Re: Permit 2005-027

Project: Belady Garage; Project address: 7627 78th Ave NE, Mercer Island, 98040

This letter is a follow-up to questions regarding the Intake Comments CST dated 6/23/2020. Particular comments are addressed below. Changes as request in the comments are identified by Delta 1 on the drawing sheets.

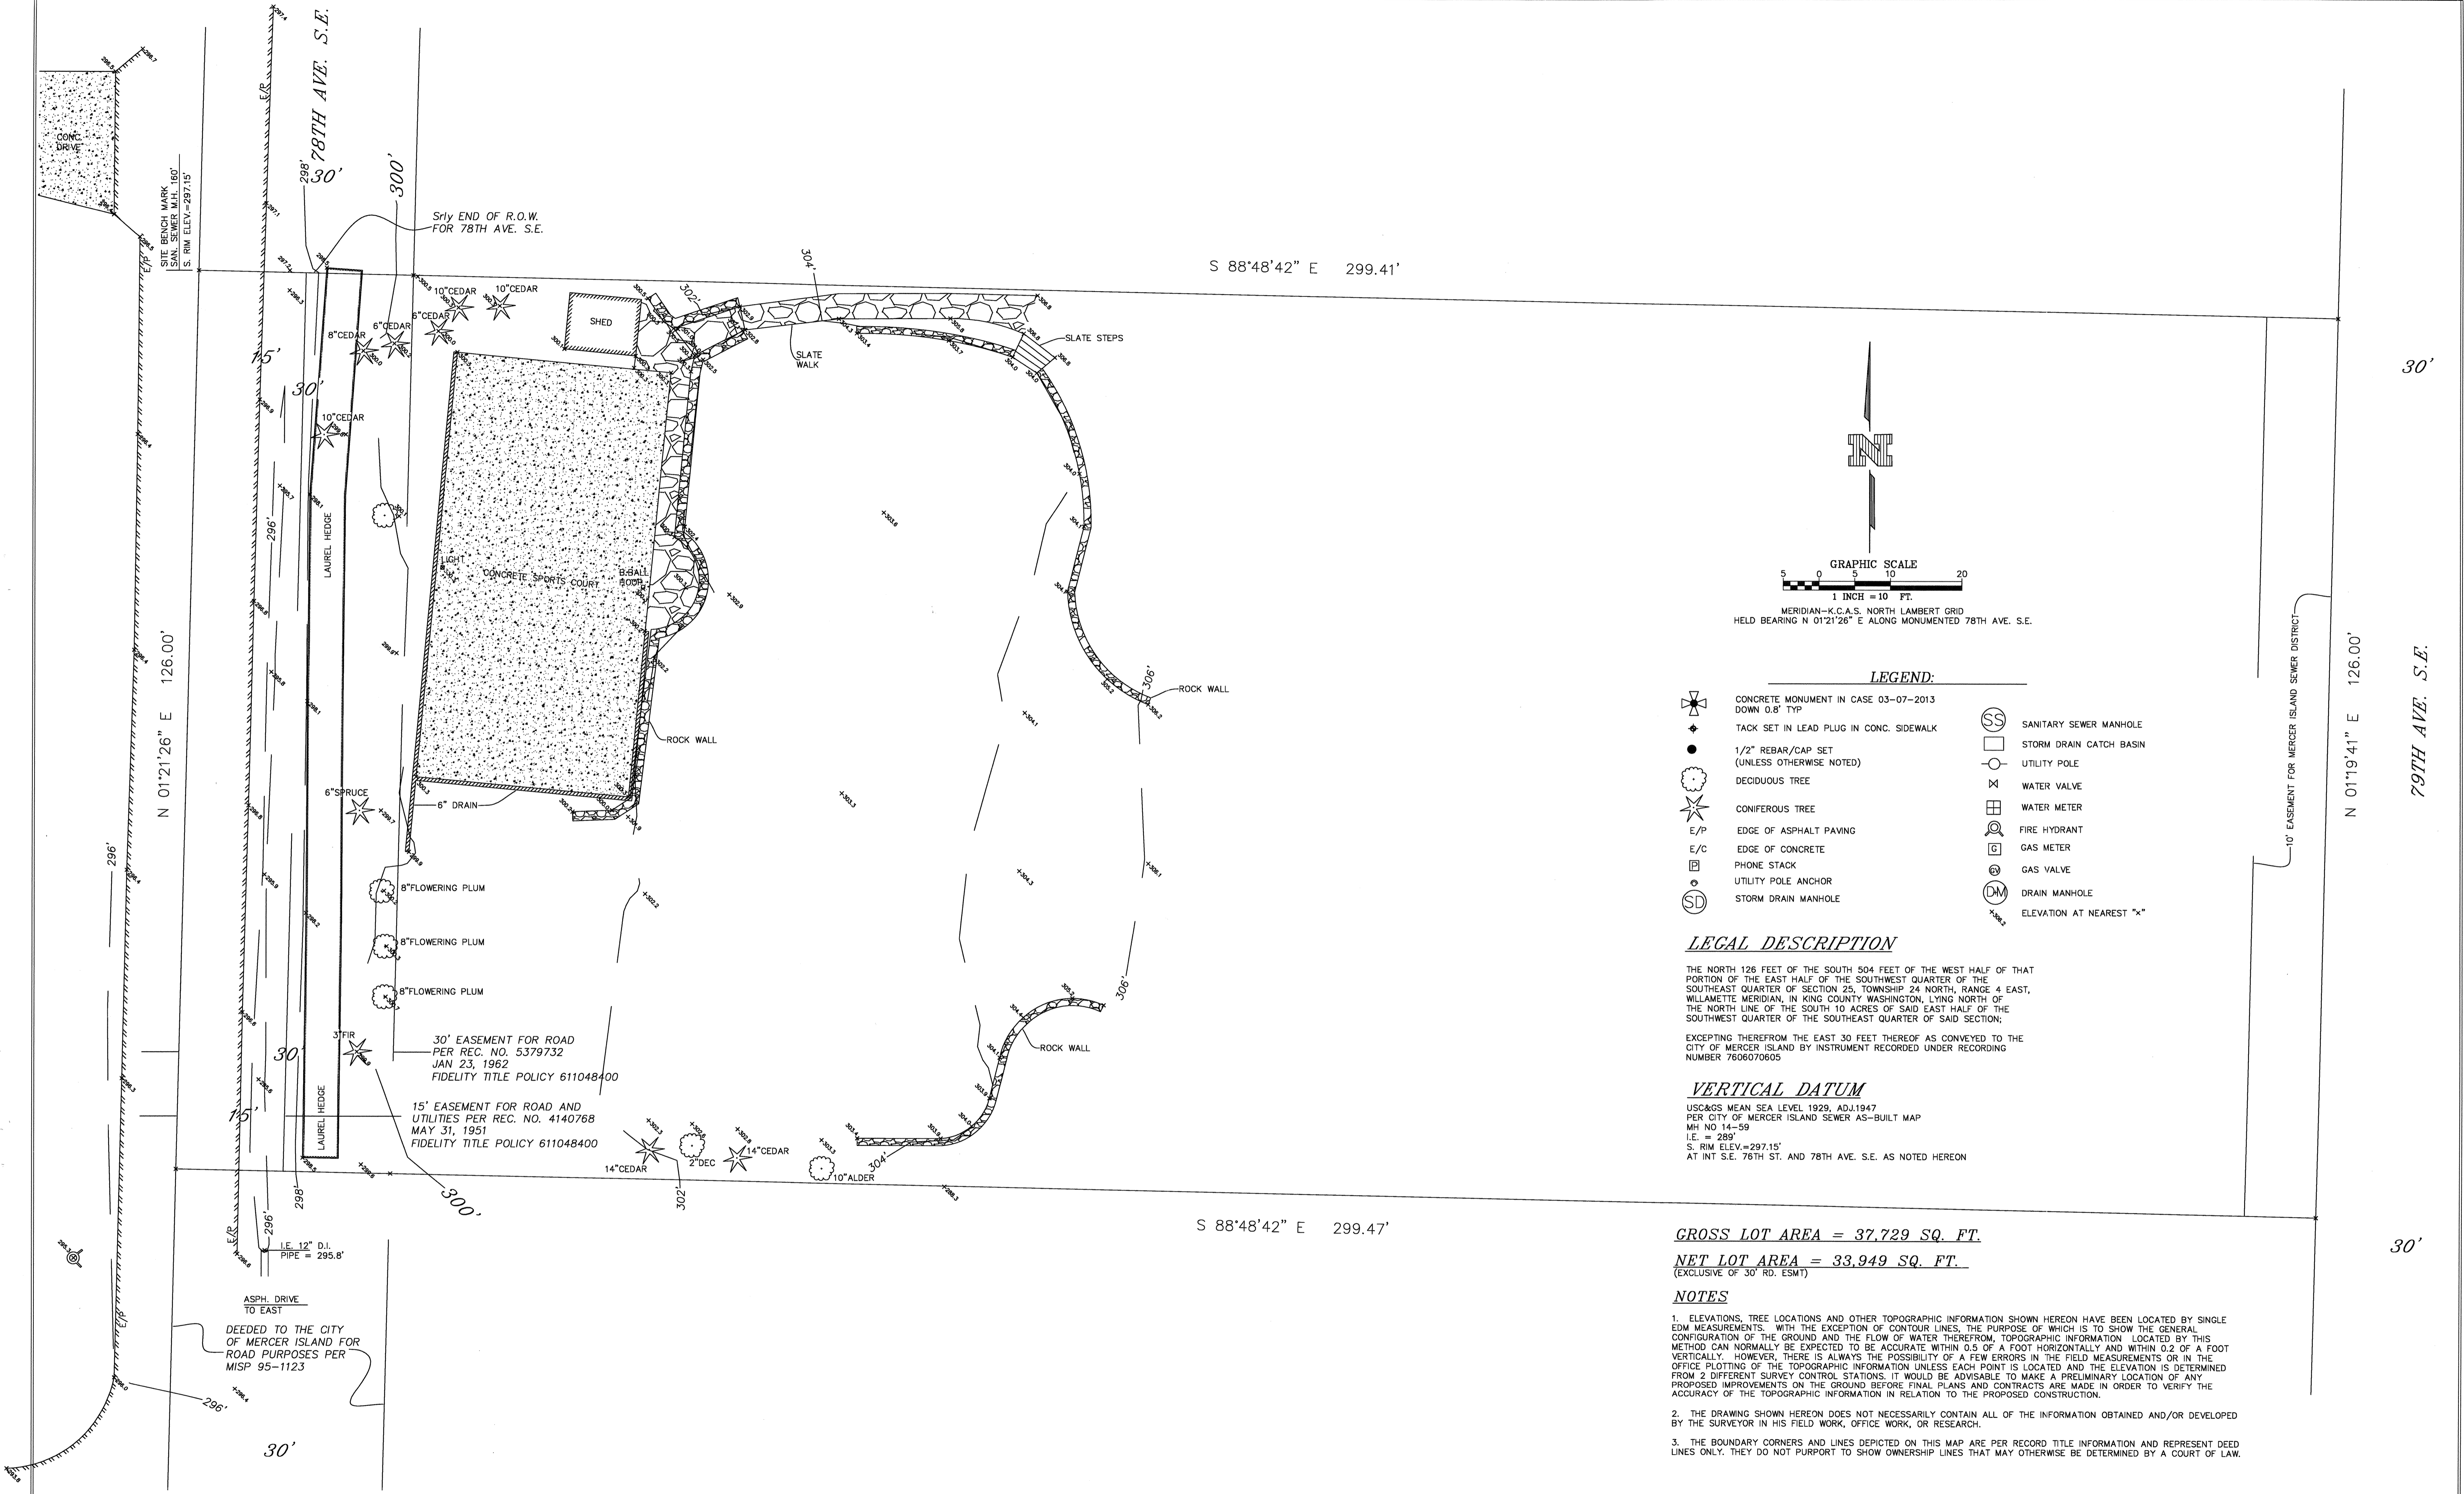
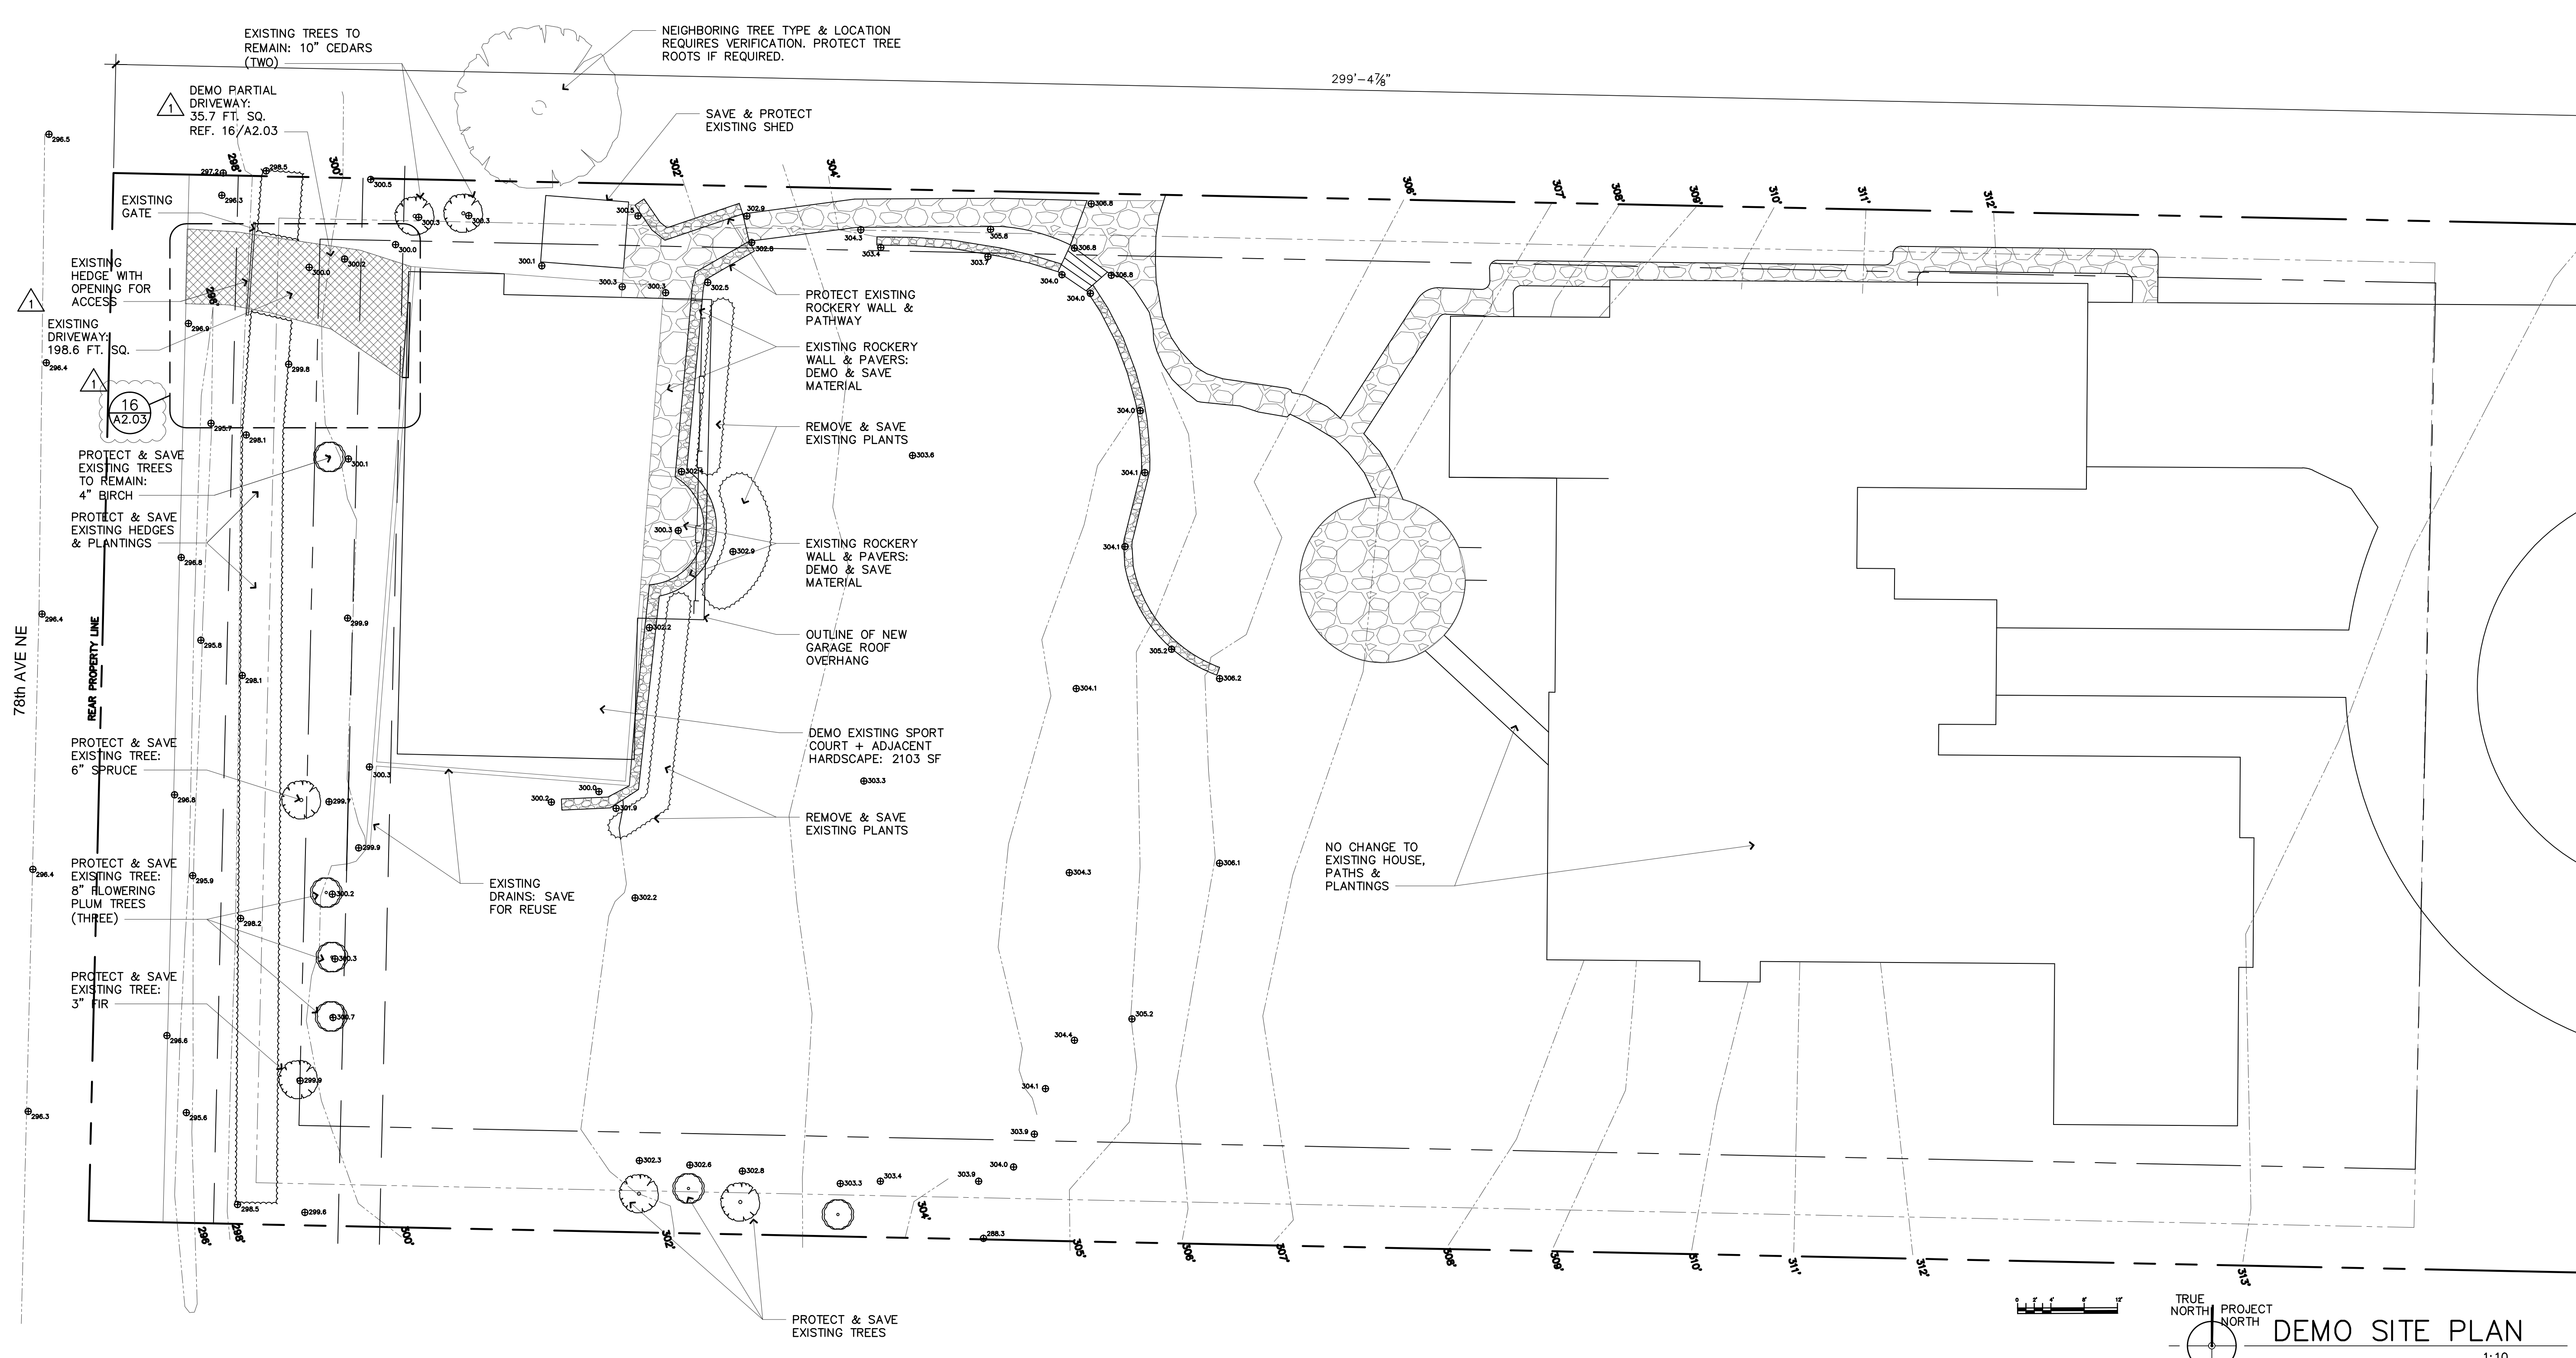
> Site Plan. Refer to sheets A1.01, A1.01 and Survey. The corrected items are identified by Delta 1 symbol, including the following; Indicate property lines and dimensions; Indicate building dimensions; Provide land use code; Topo/boundary line survey (sheet Survey); Indicated driveway length and width; Provided lot coverage, hardscape and GFA calculations (sheet A1.01); Indicate require yard setbacks.

Site Plan sheet A1.03 is updated to include Easement Recording Numbers. Setbacks and site dimensions are included. Survey sheet included in the drawing set.

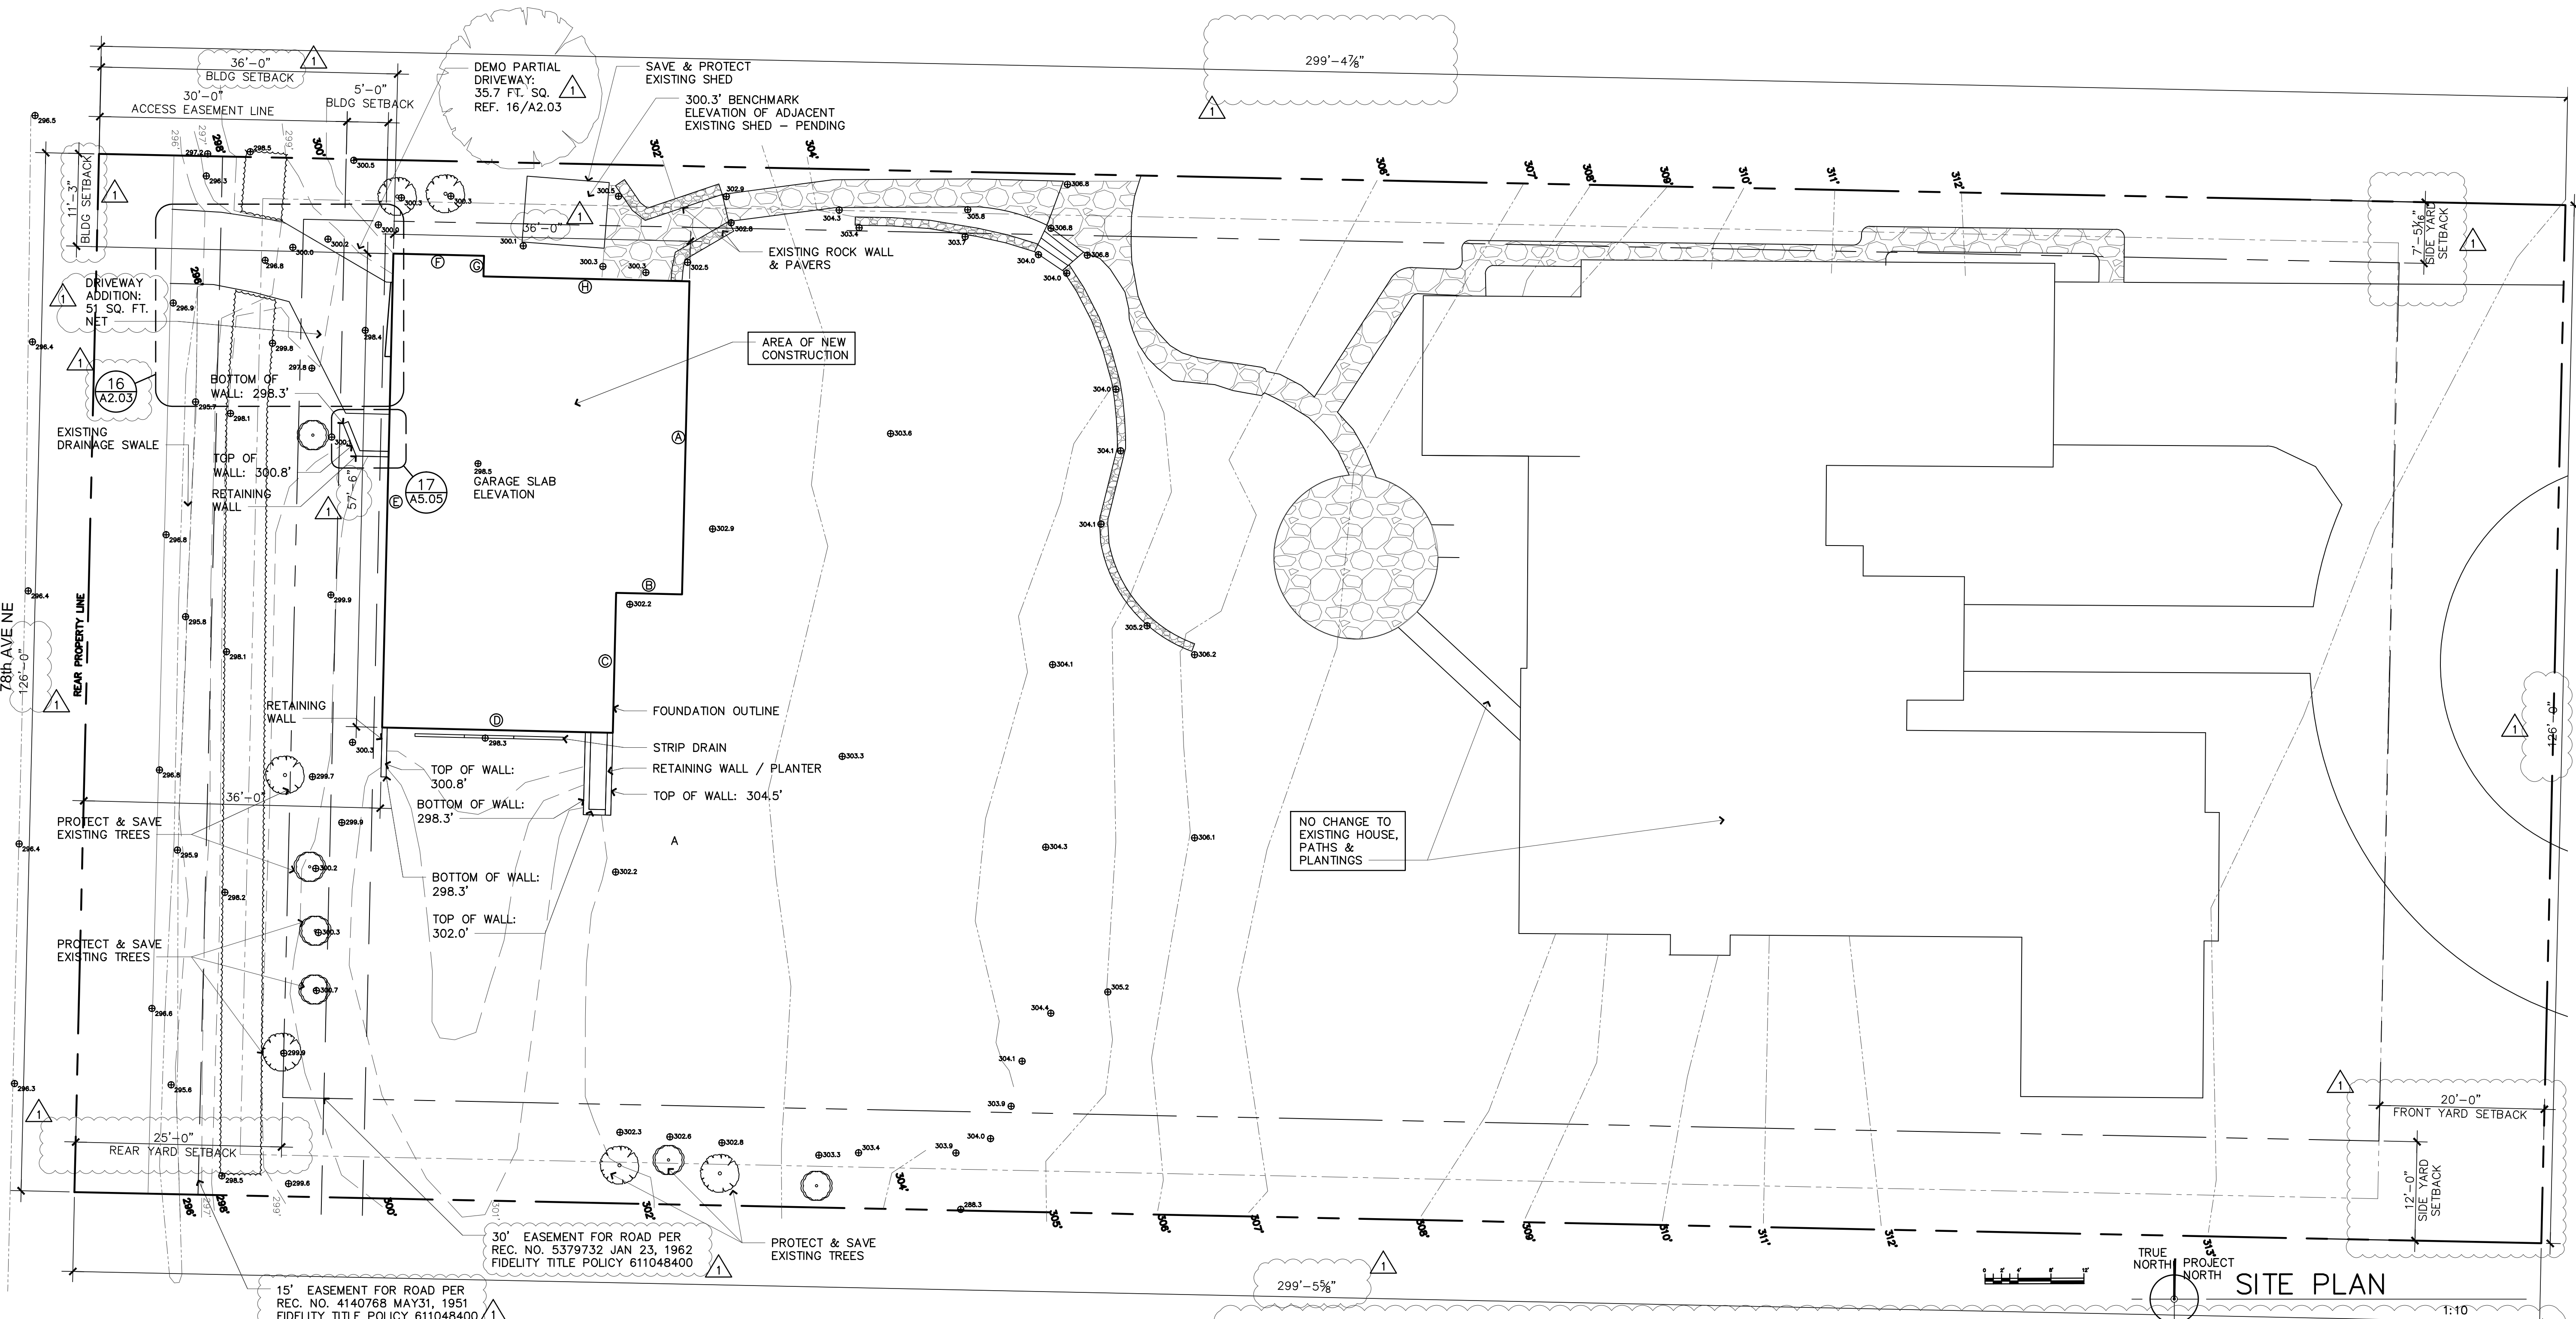
Site Development Worksheet updated to reflect changes of lot coverage for the garage. Also refer to Lot Coverage Table and Hardscape Calculation Table on sheet A1.03 regarding the percent coverage.

Net Lot Area is corrected to follow the definition that is included in the comments. The Net Lot Area includes existing driveways. Refer to sheet A1.01 Lot Coverage Calculation Diagram as well as Lot Coverage Table and Hardscape Calculation Table.
